Your Ref: OWPC18166
Our Ref: BR/18/18/PL 19-01-2018
Please ask for:
Mr S Davis

Change of use from garage & vehicle hire company to vehicle hire branch including the demolition of existing building to replace with modular unit. This application may affect the setting of a listed building.

Bruce Dixon South Bersted Garage Shripney Road Bognor Regis

Thank you for your internet representation made on 9th May 2018 which has been recorded as '**an objection**' with the comments as follows:

Drawing: Proposed Site Plan

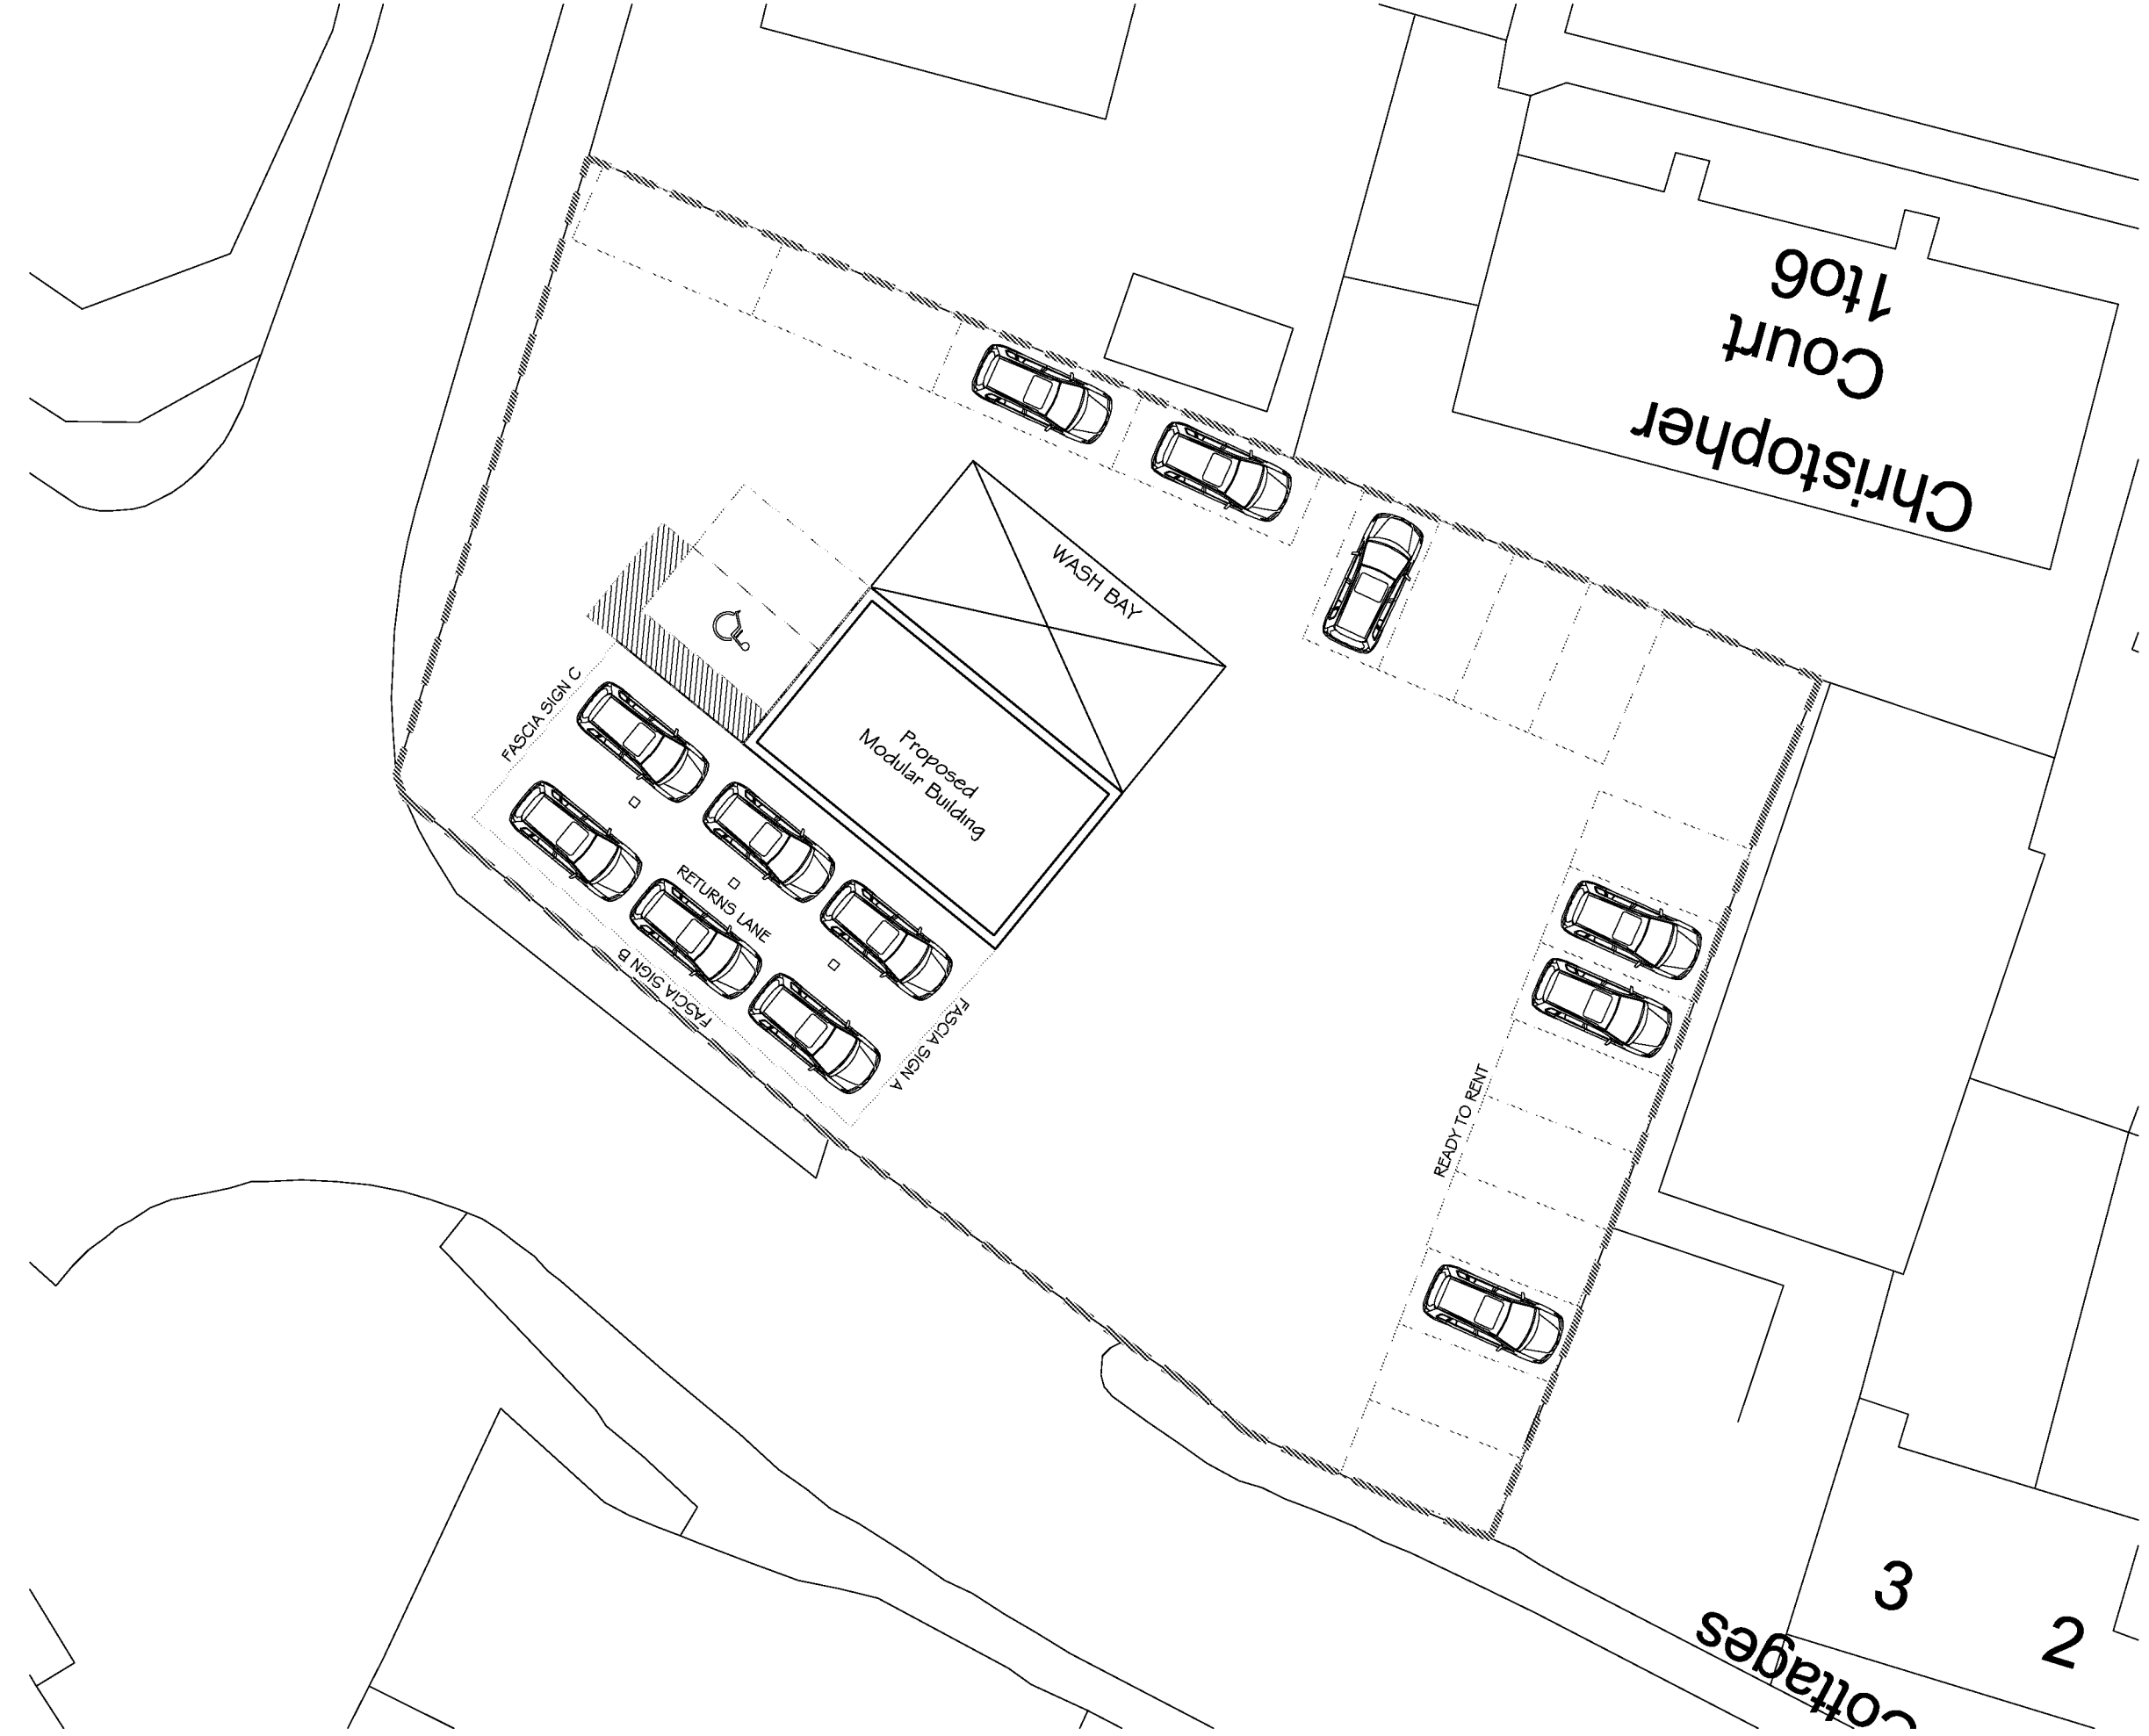
The plan shows 10 employees. Where are they going to park their cars during working hours? No provision is made for them. Also 10 different types of hire cars are shown, the statement says a few of each type of car is kept on the site. What is the total number going to be?. There are only 17 parking spaces in total shown on the proposed plans. How is a 10mtr transporter going to navigate into the site and which access road will it use.? The surrounding road are all residential and are already clogged up all day by employees cars from the Nissan Garage, Shripney Road, there are 6 cars from the garage in my road, as I write this. Please carefully consider that this is a residential area, already clogged with cars and cannot cope with any more.
